EF13/5058, DOC17160088-01
SSD 7787

SSD 7787 – KELLYVILLE SOUTH PUBLIC SCHOOL – EIS

ATTACHMENT A
- ENVIRONMENT PROTECTION AUTHORITY COMMENTS -
KELLYVILLE SOUTH PUBLIC SCHOOL

Figure 2-1 Site Layout

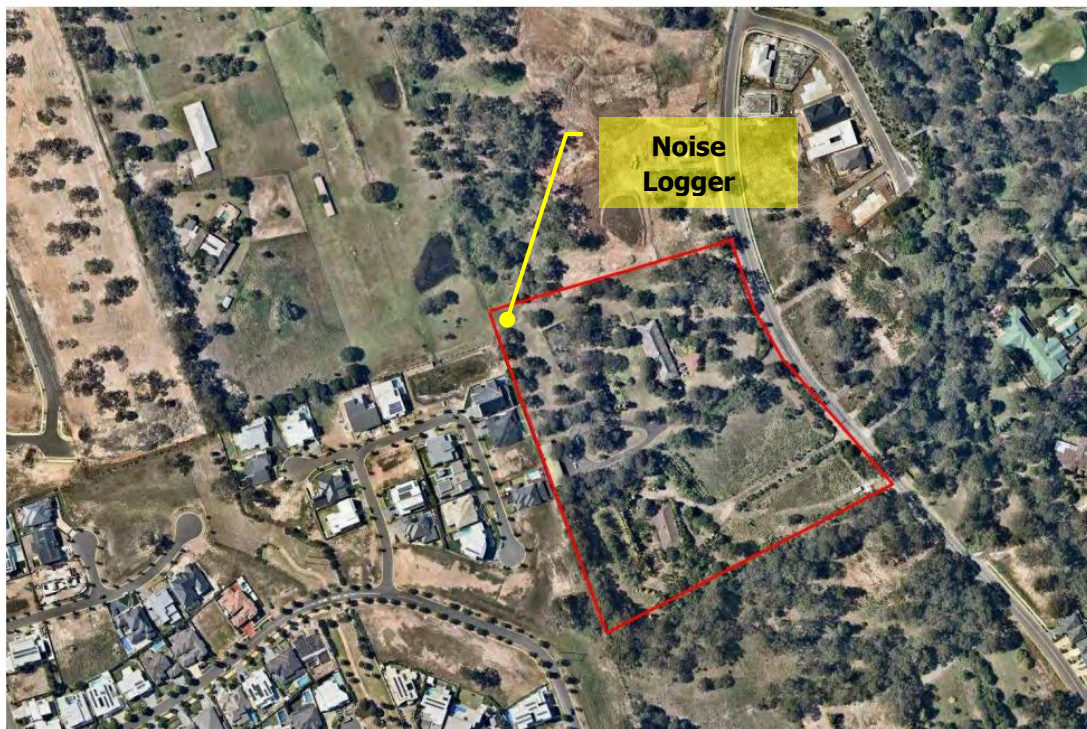
Figure 2-1 to EIS Appendix U indicates that background noise monitoring was undertaken in February 2017 in the northwest corner of the development site but not at the boundary of the "... most potential [sic] affected residences ... " to the west (i.e. Charlemont Terrace and Brighton Drive) of the sports hall and outdoor sports court.

- (a) clarify why the background noise monitoring was not undertaken at the boundary of the most affected residences, and
- (c) confirm whether the adverse wind and rain affected data (see monitoring graphs) was excluded per the guidance provided in INP Chapter 3 and Appendix B.

The proponent be required to justify departures from the guidance material concerning background noise monitoring as provided in the New South Wales Industrial Noise Policy.
